**PRELIMINARY DRAINAGE REPORT AND MDDP ADDENDUM
FOR
HOMESTEAD NORTH AT STERLING RANCH PRELIMINARY PLAN**

Engineering Review

**PCD Filing No.:
SP-20-008**

HOMESTEAD NORTH AT STERLING RANCH
EARLY GRADING & EROSION CONTROL PLAN

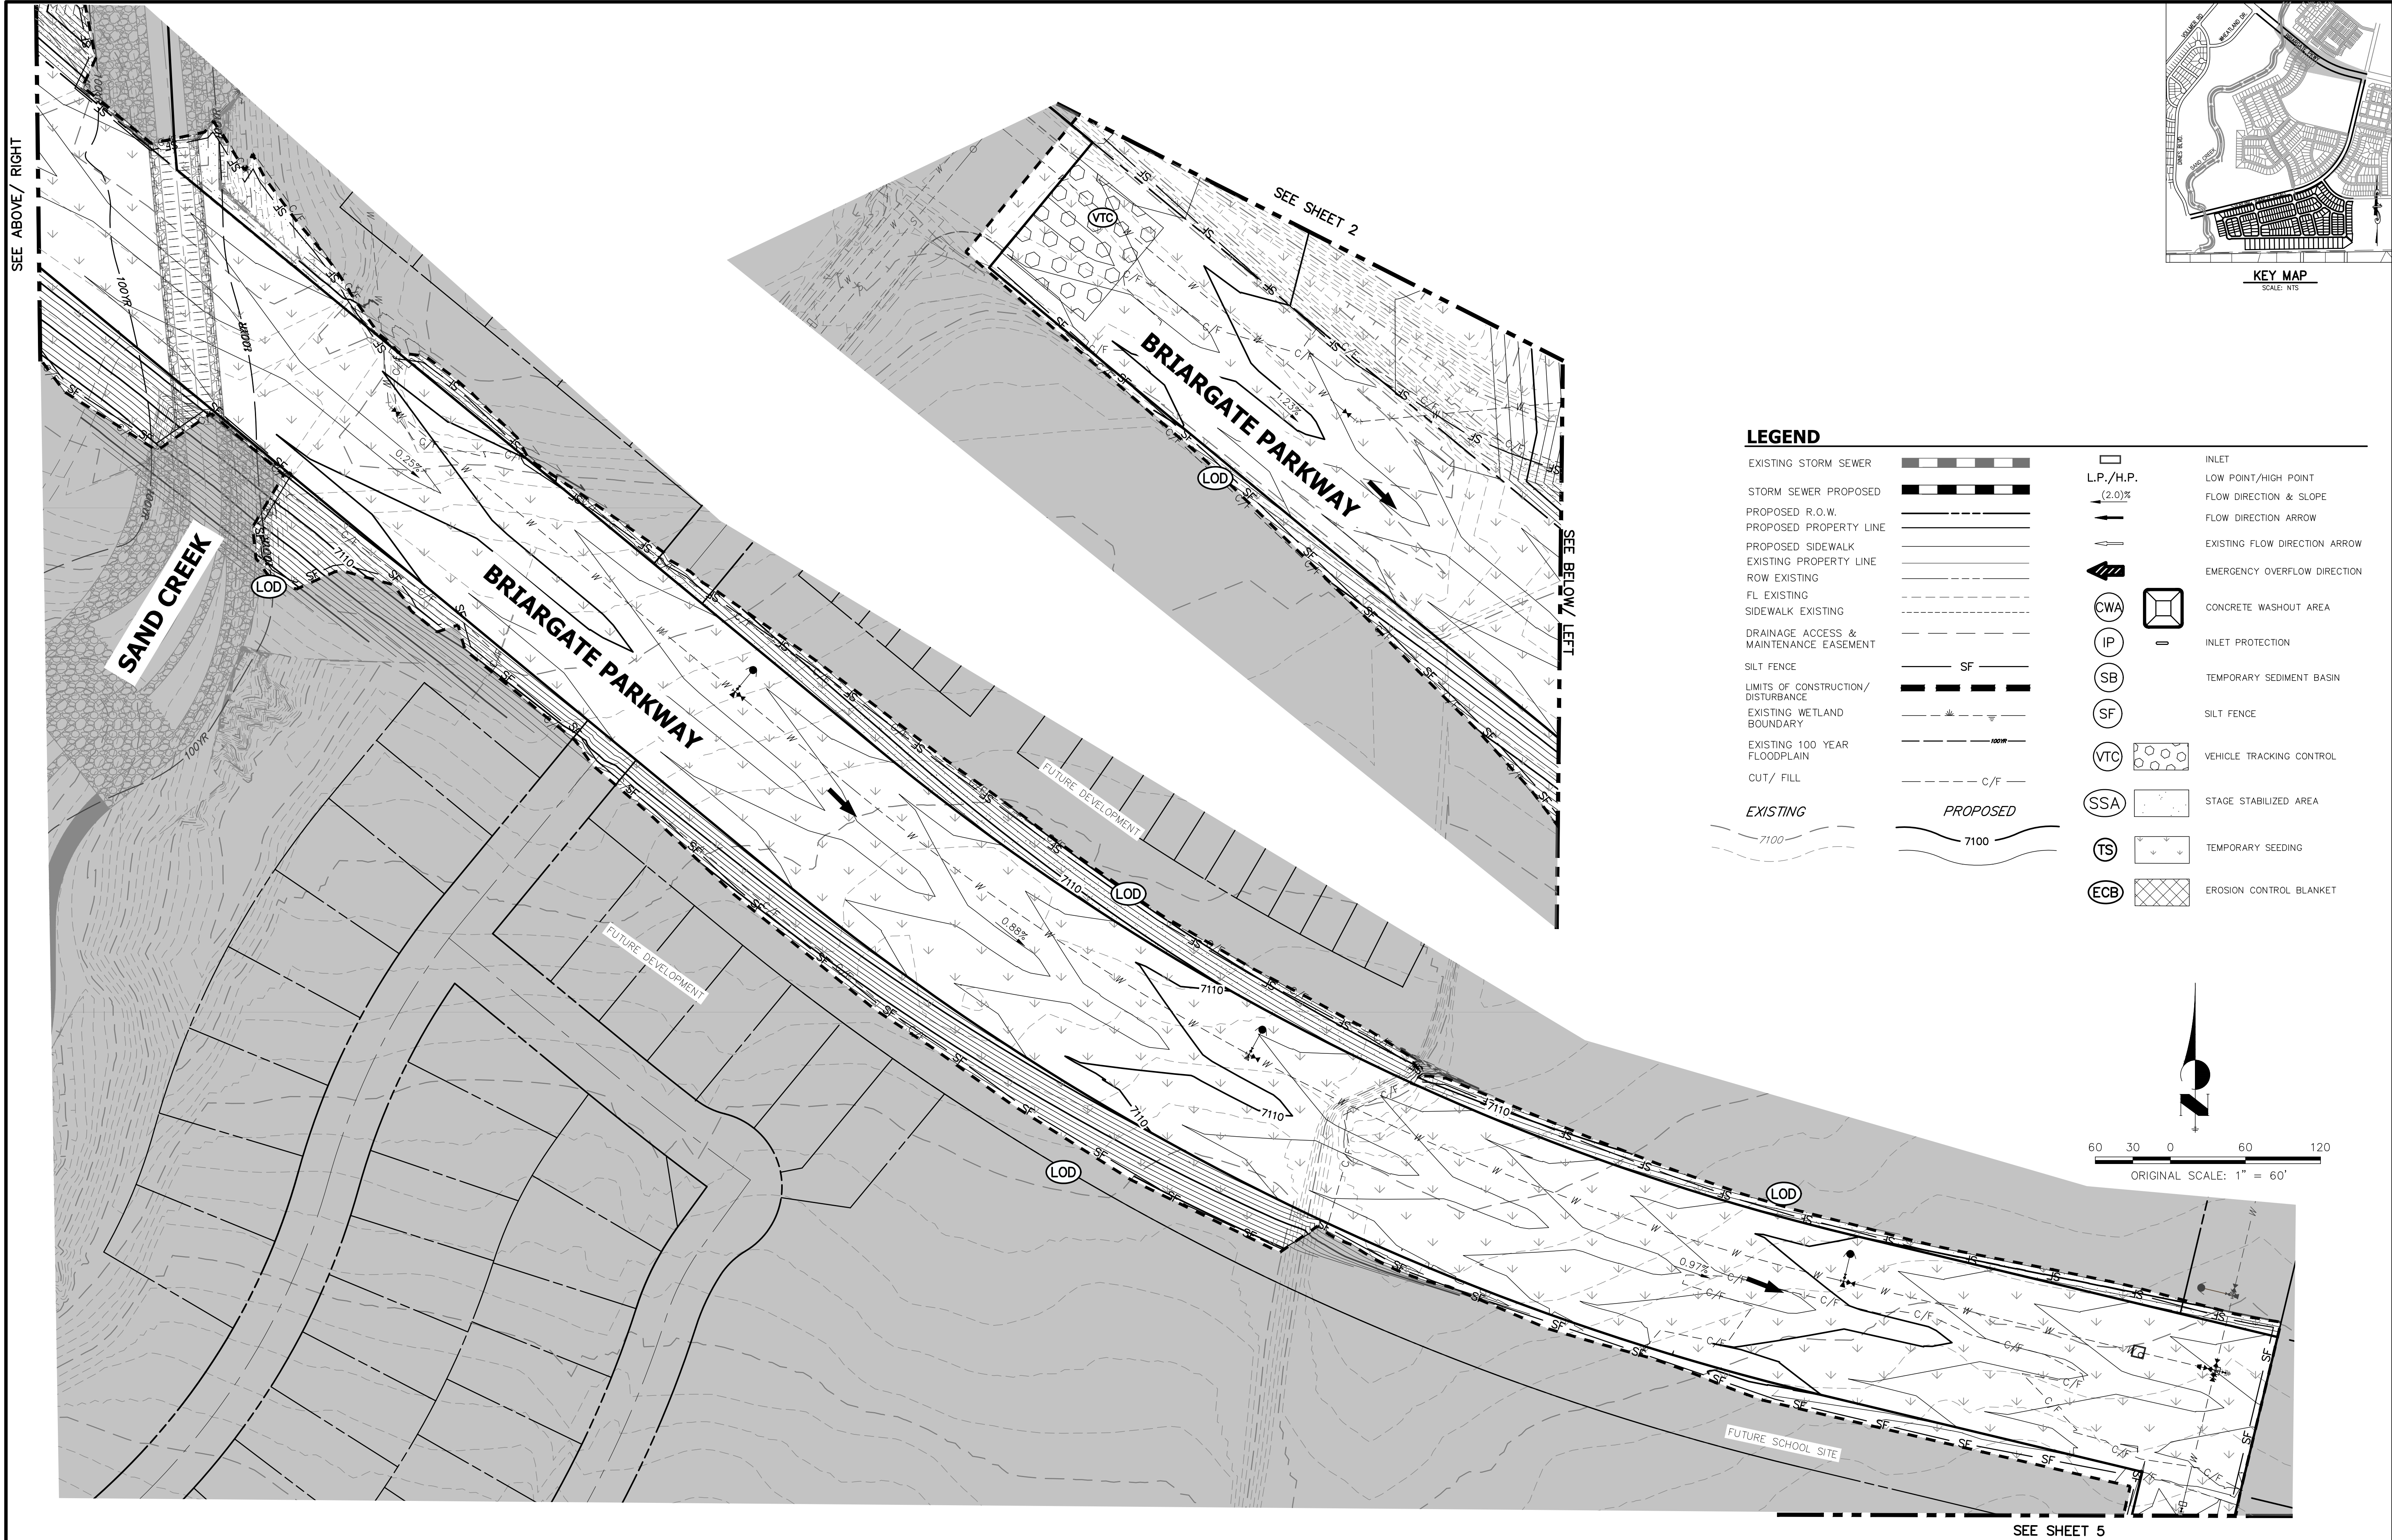
If Briargate Pkwy and Sterling Ranch Road are included in early grading, details to the FDR level will be required. See comment letter.

JR Response: FDR for Sterling Ranch road and Briargate will be submitted seperately
